Your ref: SSD-50505215

Our ref: DOC24/699892

Subject: Bullawah Wind Farm (SSD-50505215)

ATTACHMENT A – BCS Assessment Summary for Bullawah Wind Farm Environmental Impact Statement (SSD-50505215)

J:\2067-05 Bullawah WRIA\GIS\OGIS\2067-05 Figures\agz Flood velocities Project are A3\ Exported: 11 June 2023
Projection: EPSG:7855

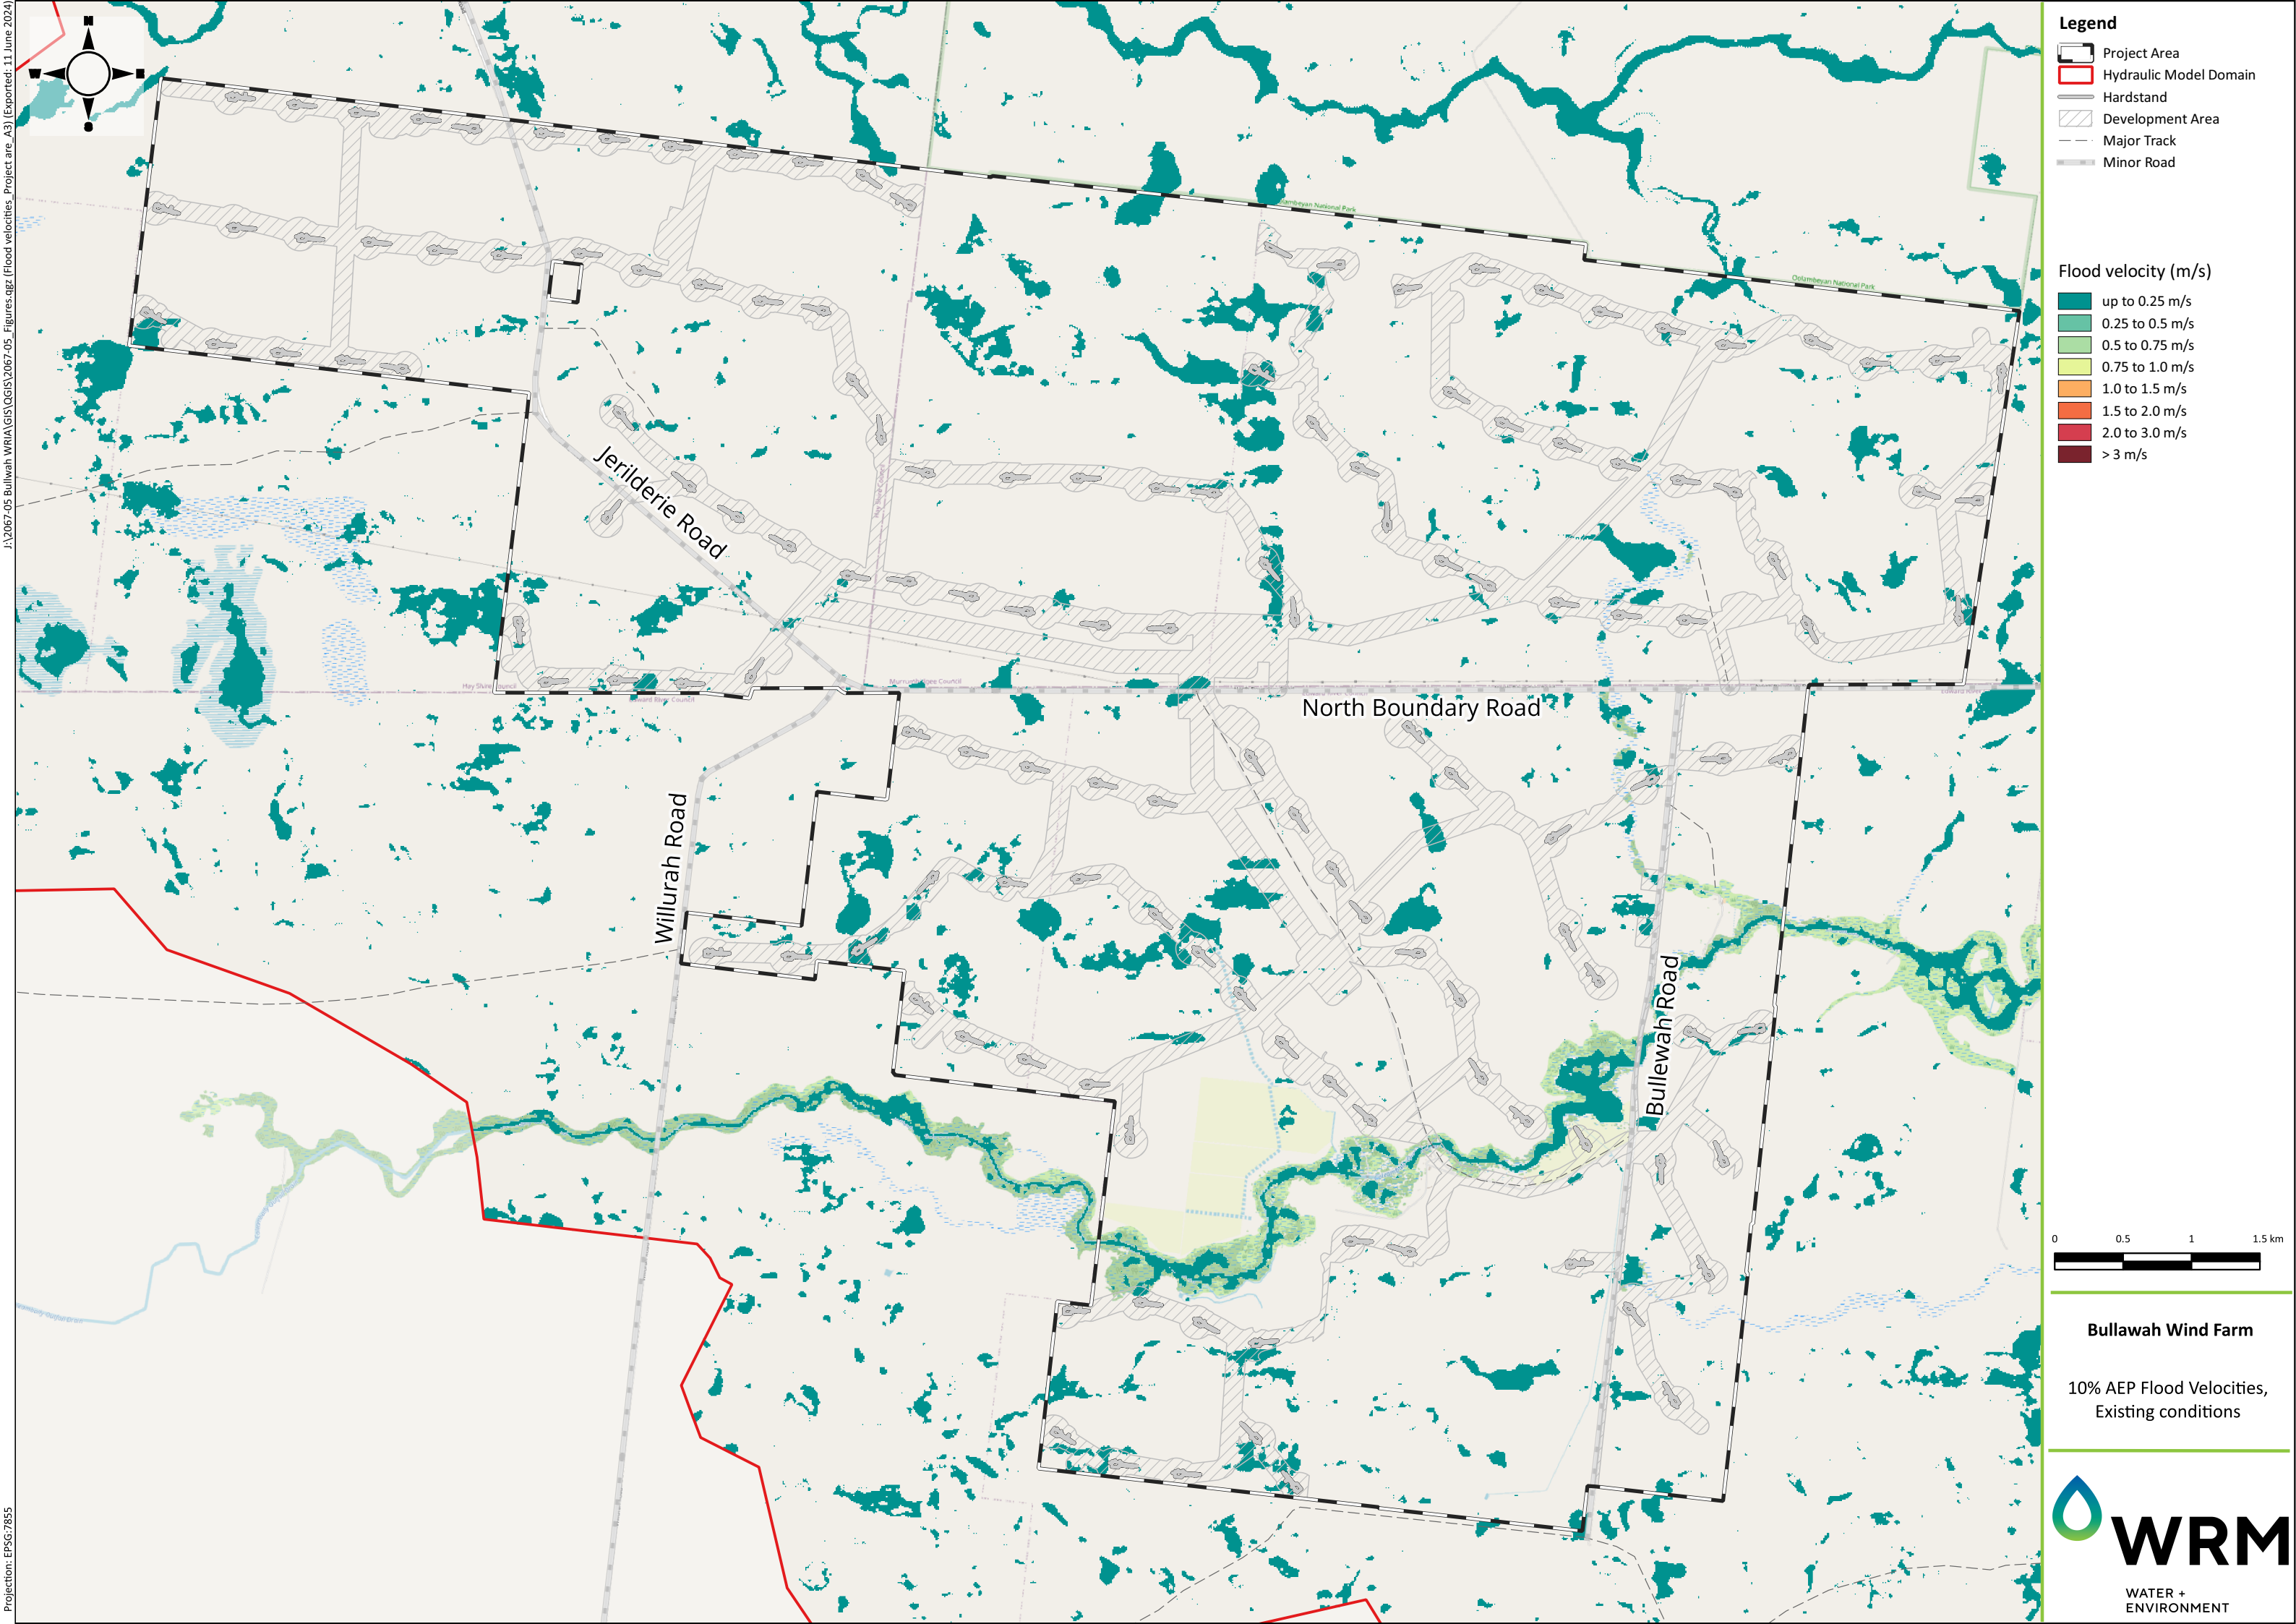
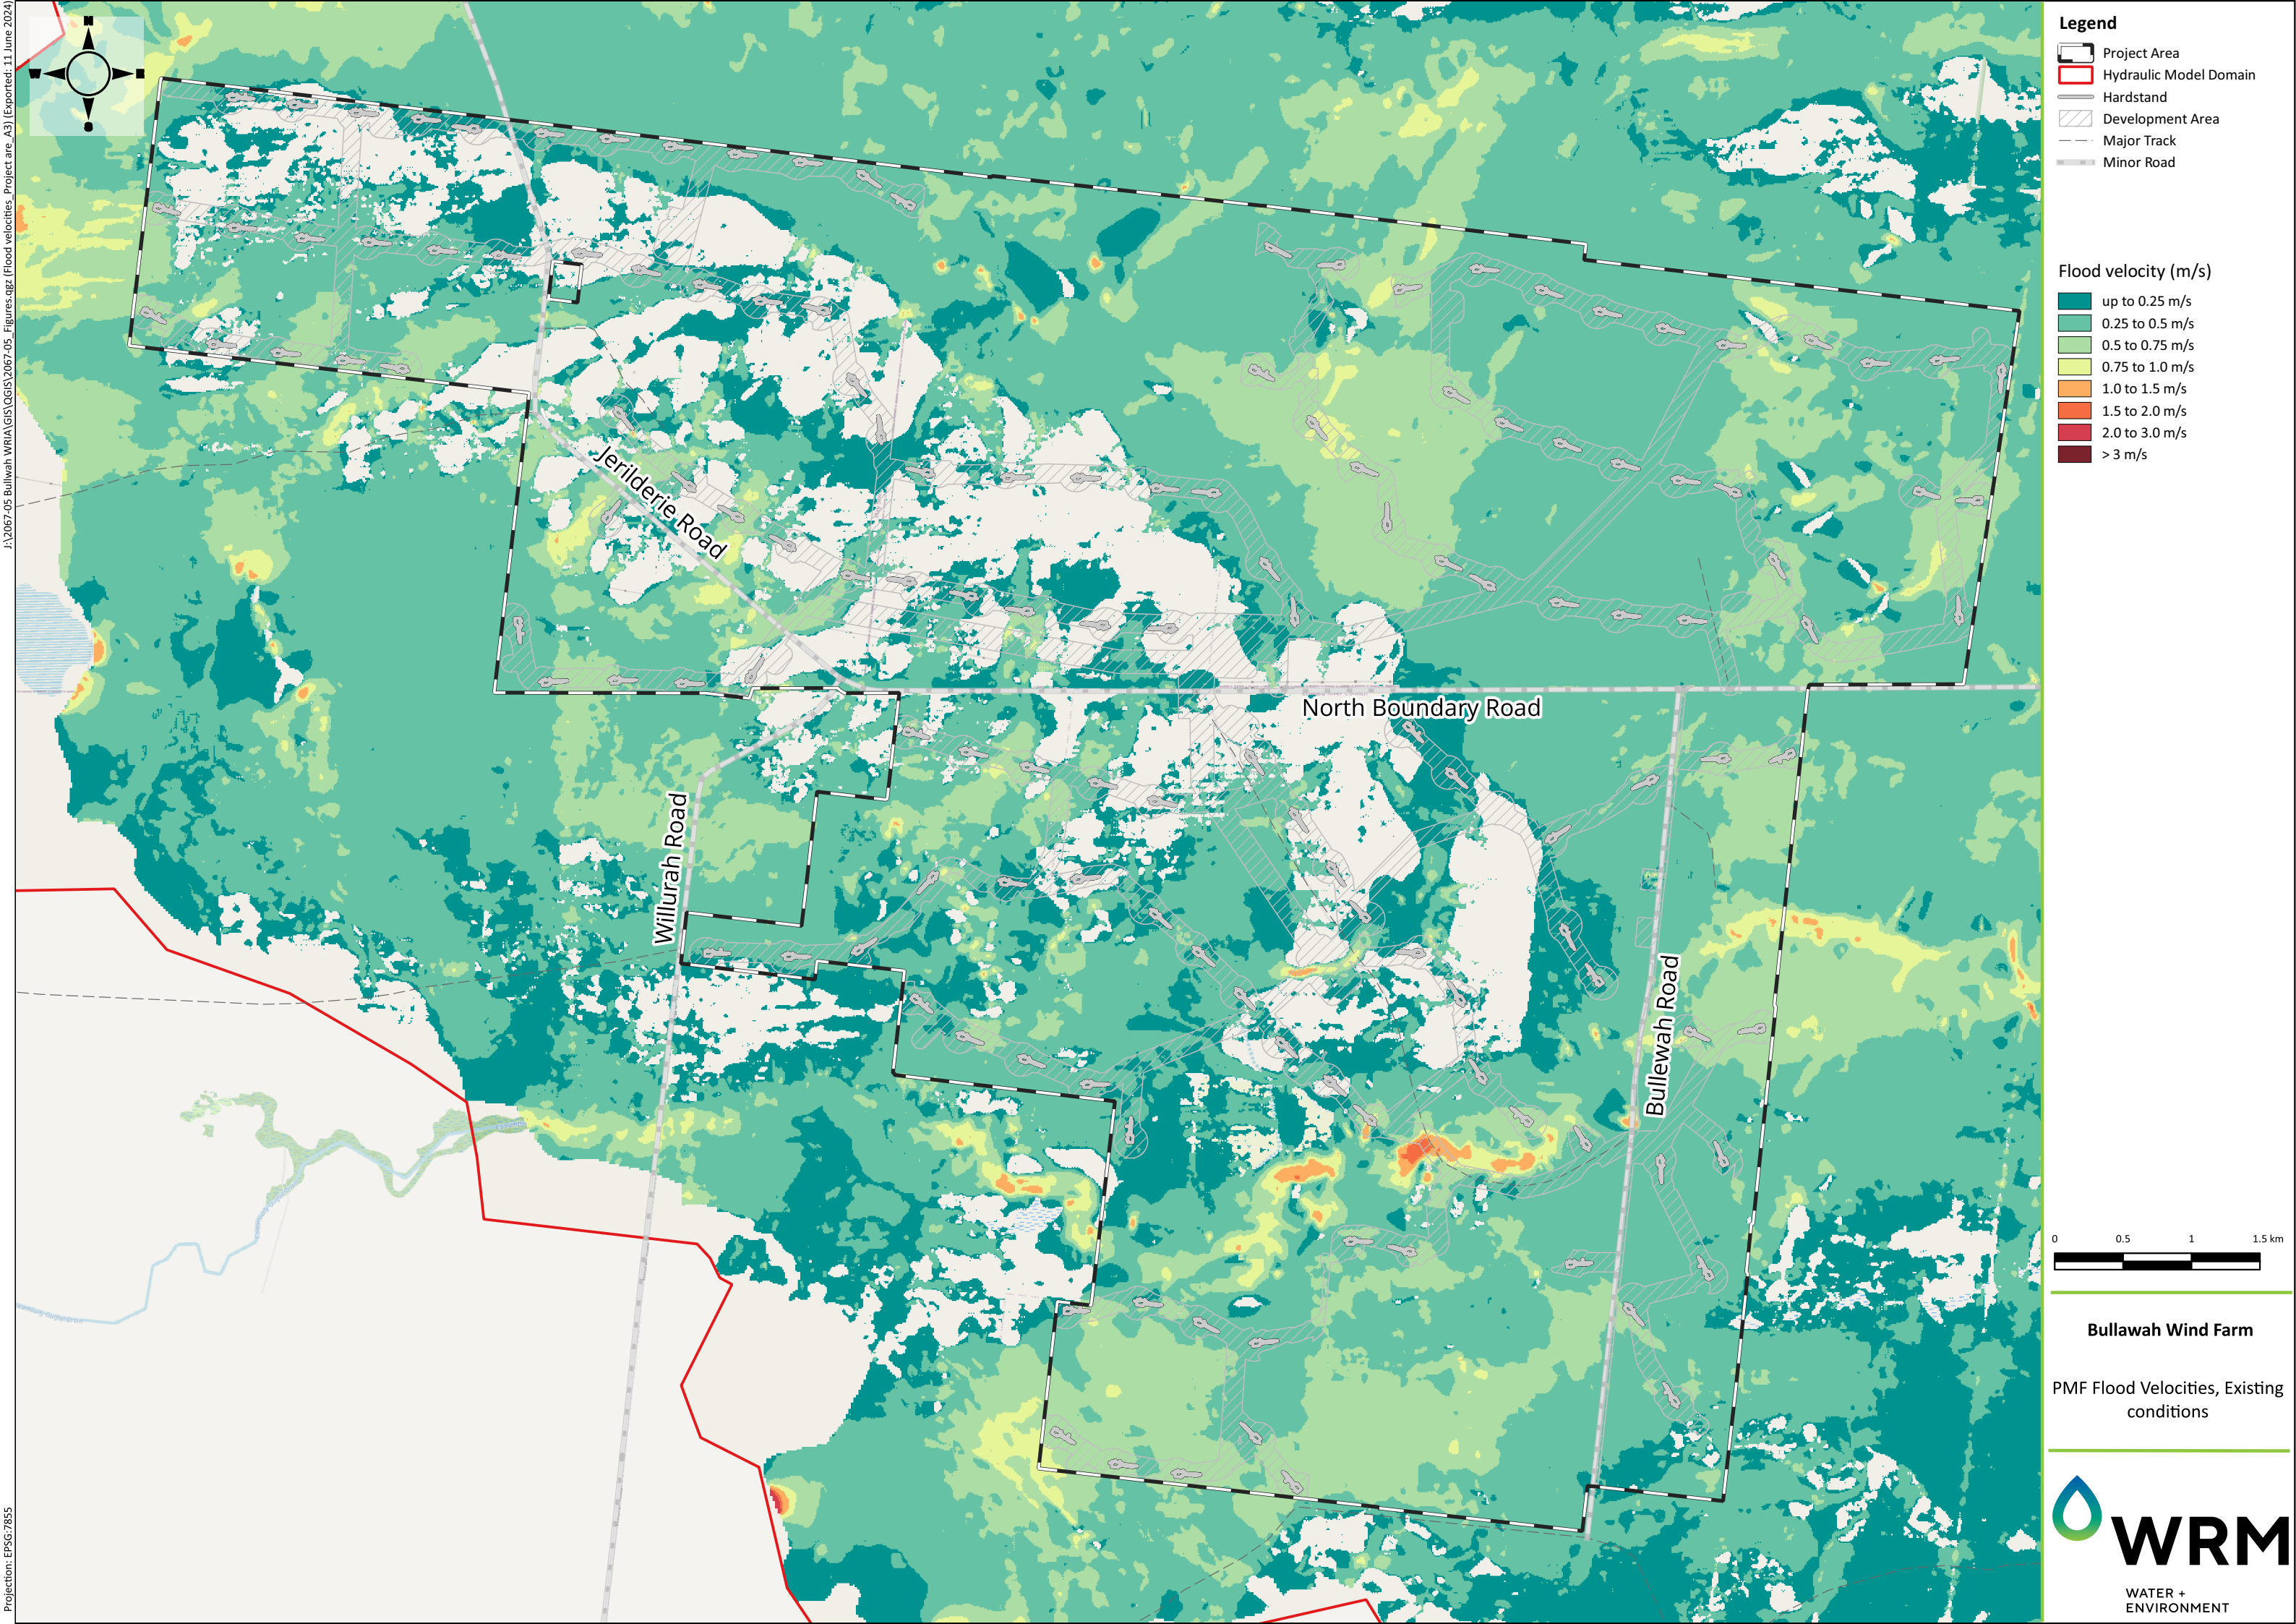
3. The flood modelling and mapping needs to include more detail of the project infrastructure to adequately inform the flood behaviour and flood risk assessment.

The Bullawah Wind Farm Project Water Resources Impact Assessment provides low-resolution mapping in its overview of the project. The mapping provides limited detail of the proposed project infrastructure, including ancillary works, in the landscape. As such, BCS is not able to determine the impact of the entire project on flood behaviour and the flood risks to the project infrastructure.

The proponent needs to complete clear and detailed mapping of sensitive and hazardous infrastructure, such as the temporary workers' accommodation, battery storage and multiple substations to allow appropriate flood risk assessment to be completed. BCS recommends that future hydraulic modelling is based on the detailed design for the project infrastructure, which will include all aspects of development, to ensure the impact of the project on flood behaviour and the flood risks to critical project infrastructure are adequately assessed.

- 3.1. Ensure future hydraulic models include the detailed design for the proposed project infrastructure to ensure the impact of the project on flood behaviour and the flood risks to critical infrastructure are adequately assessed.
